Stormwater

18 December 2007

RE: PROPOSED DEVELOPMENT FRASER DRIVE MP06- 0243

FIGURE No.DA 20
POST DEVELOPMENT
STORMWATER NETWORK

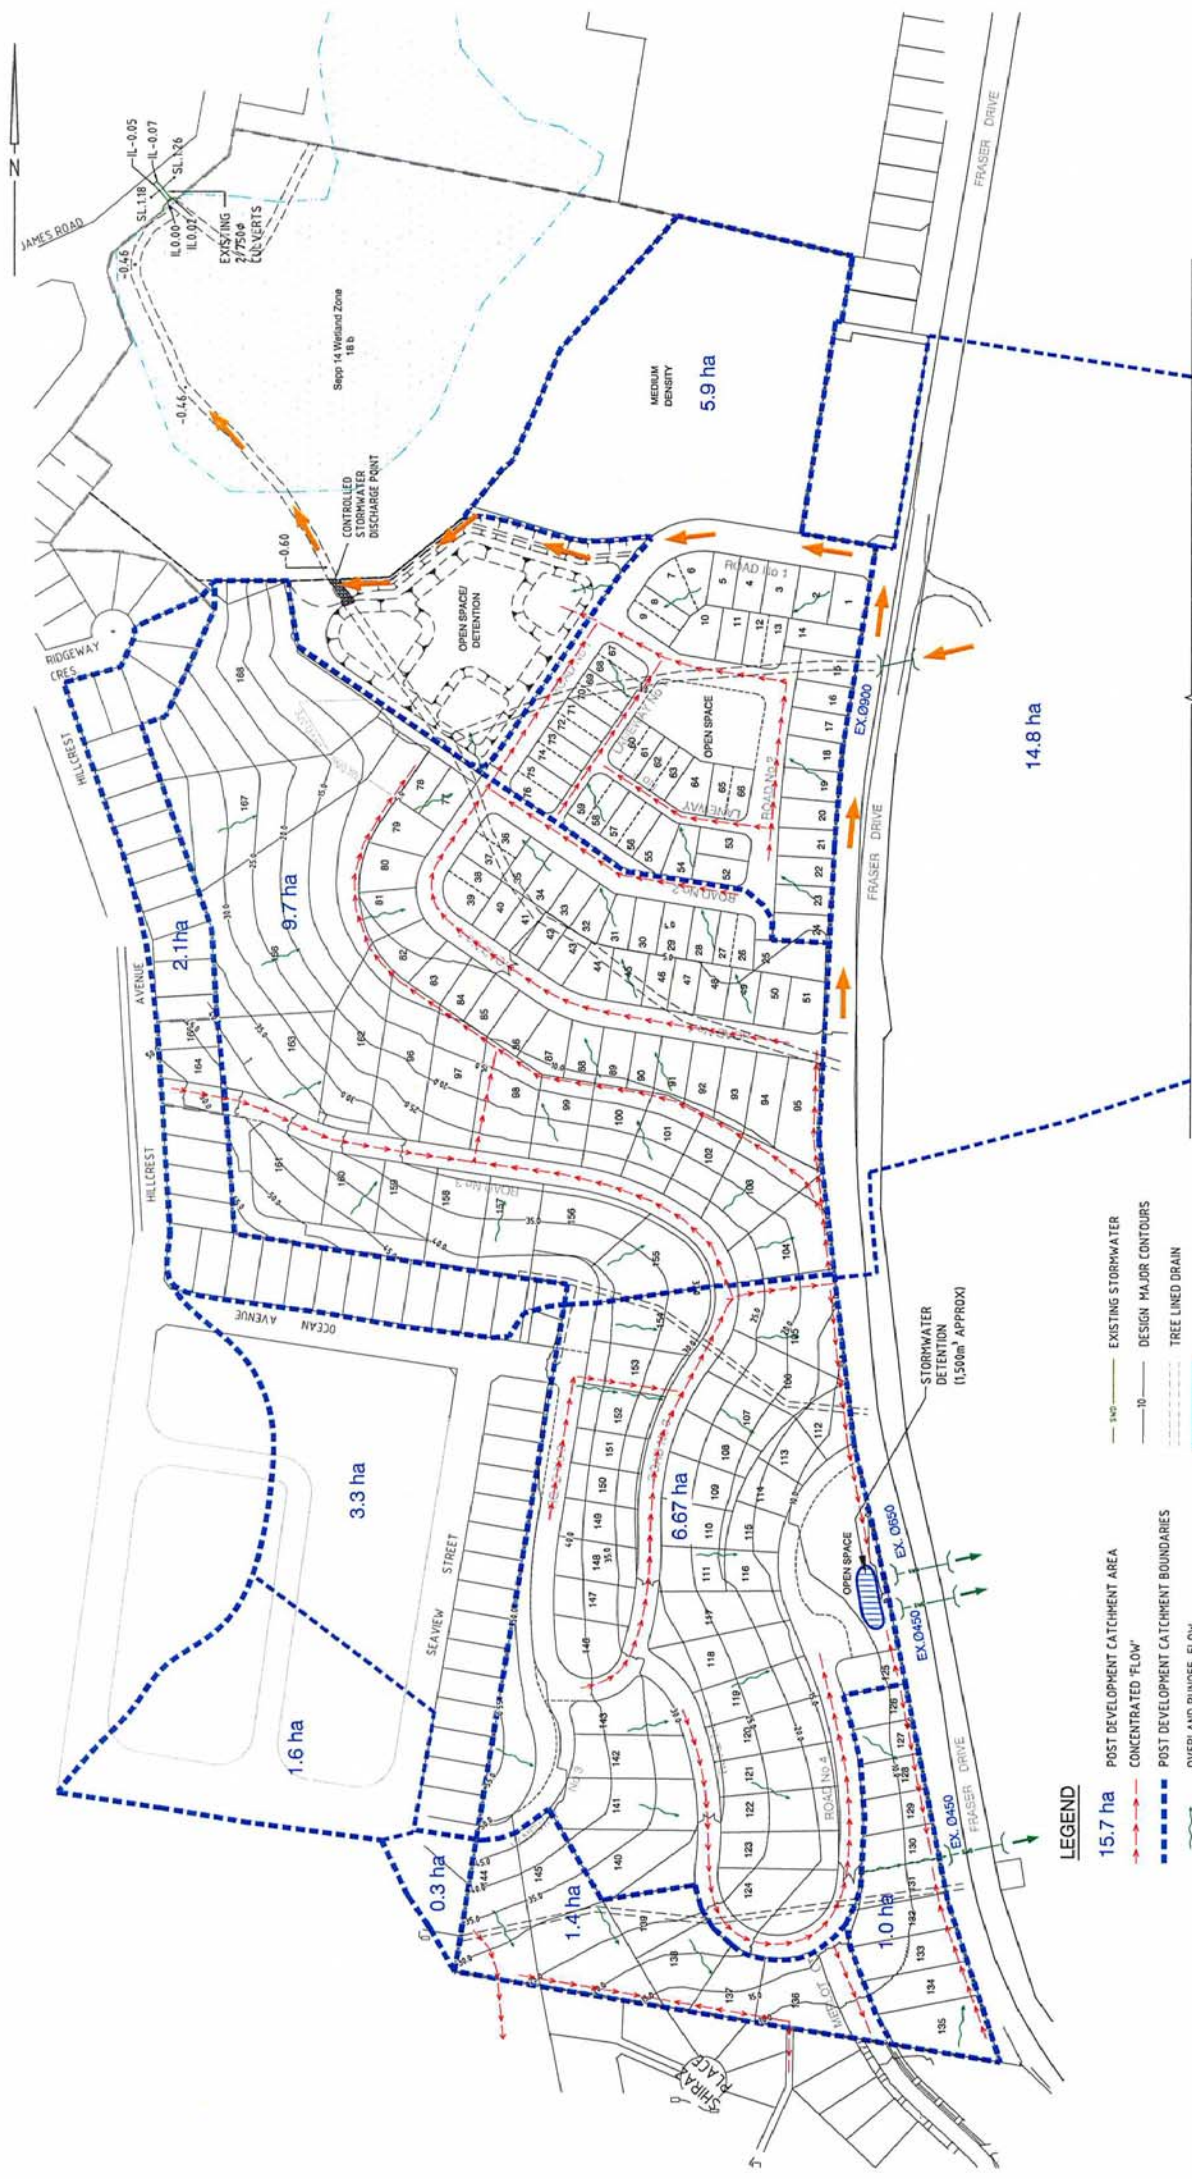
- 33. Provide an assessment of the existing cross sectional capacity of the open channel through the SEPP14 wetland, downstream of the subdivision. This assessment shall include a design and plan of works to upgrade this channel as necessary to cater for post development flows from the subdivision.**

The existing drain, by survey, has no capacity. It grades up hill and in some places is over 0.5m lower than outlet at James Road. See Figure DA 20 which shows levels. The regime is to maintain existing flows into the channel and wetland by detention control. The channel should remain unchanged to maintain ecological balance.
